From: toby foster-grundy [REDACTED]
Sent: 31 January 2014 15:05
To: Janice Chapman
Cc: Toby Foster-Grundy
Subject: Re: AW/331/13 - Extensions, balcony and carport at 3 Shorecroft, Aldwick

From: Janice Chapman
Sent: 02 January 2014 16:27
To: [REDACTED]
Subject: AW/331/13 - Extensions, balcony and carport at 3
Shorecroft, Aldwick

Site Plan
Existing and
Proposed

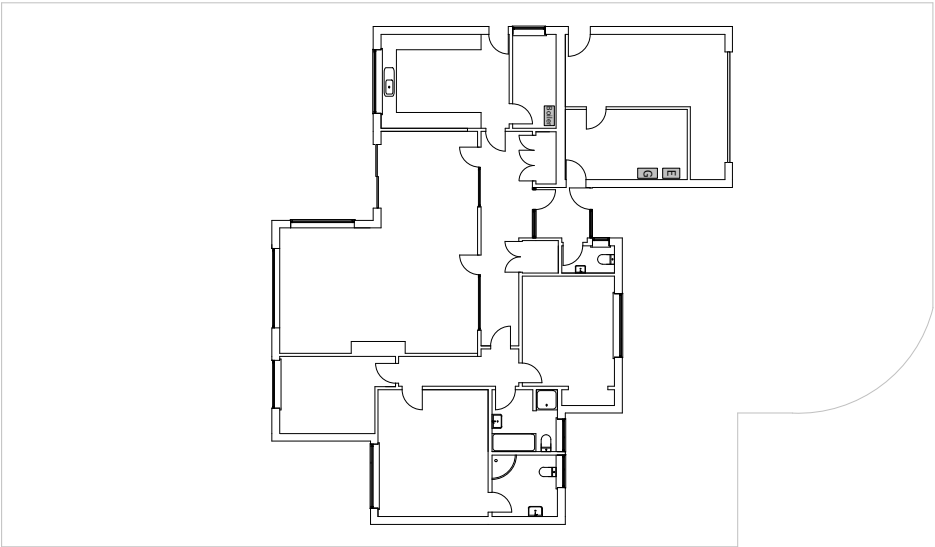
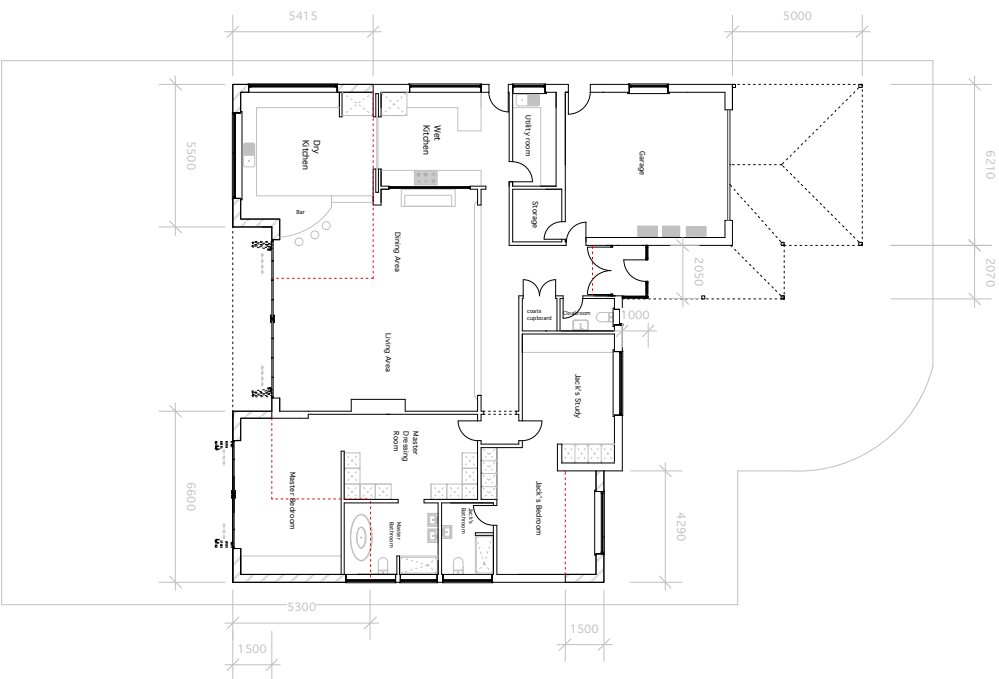
I am the case officer dealing with the application. The site was visited on the 20th December and whilst the front and rear extensions plus balcony are considered to be acceptable the carport forward of the property is considered to be out of character within the street scene. At the present time I could not recommend approval and would seek that the car port be removed from the application. Would you discuss with your client and advise me accordingly as obviously the plans will have to be amended.

I will forward the revised plans omitting the car port

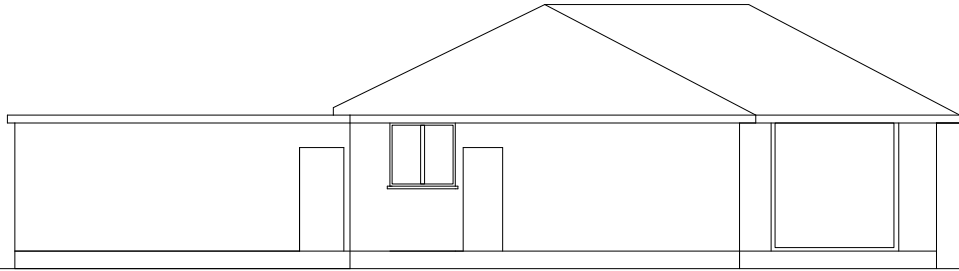
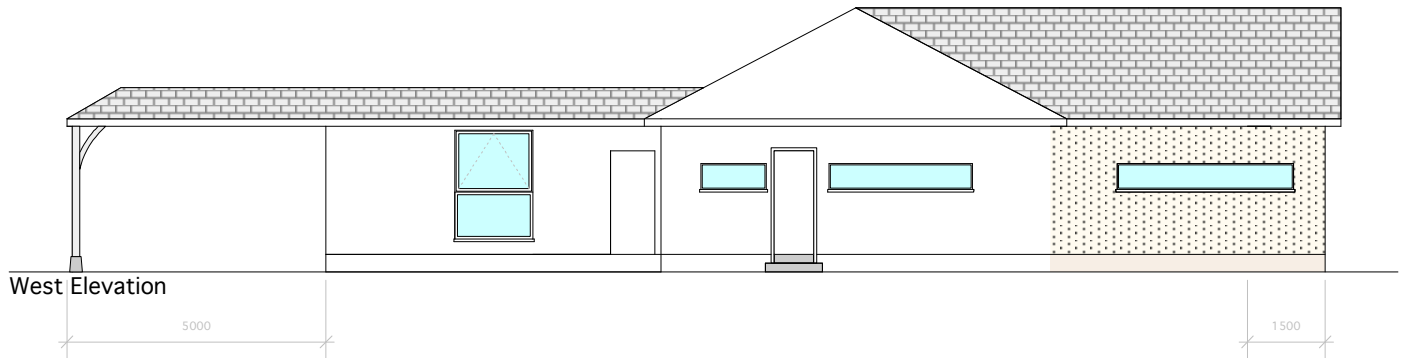
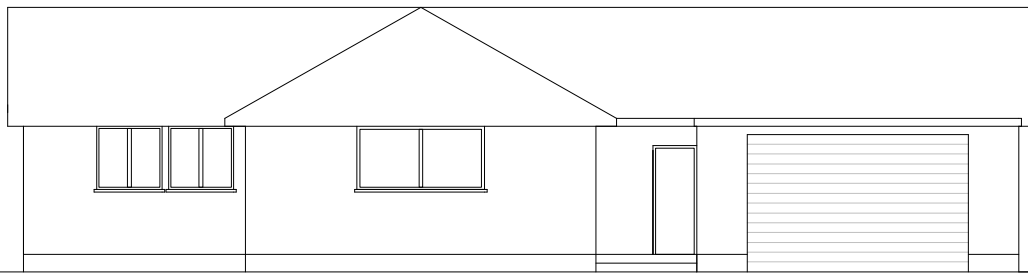
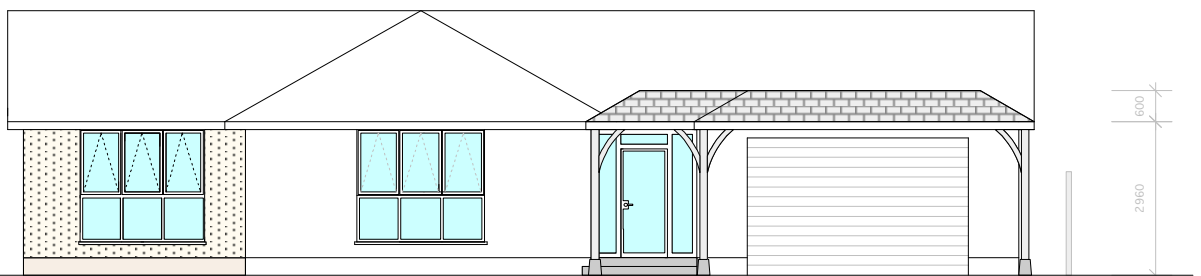
As the existing dwelling is painted render it is not clear from the drawings where the cedar cladding is to be installed. Please can you confirm.

I understand and render it is.

I would prefer that the dwelling and extension remain in render.

Cedar cladding is potentially going to be on the rear elevation only.

If this is too controversial we can happily revert to painted render as existing
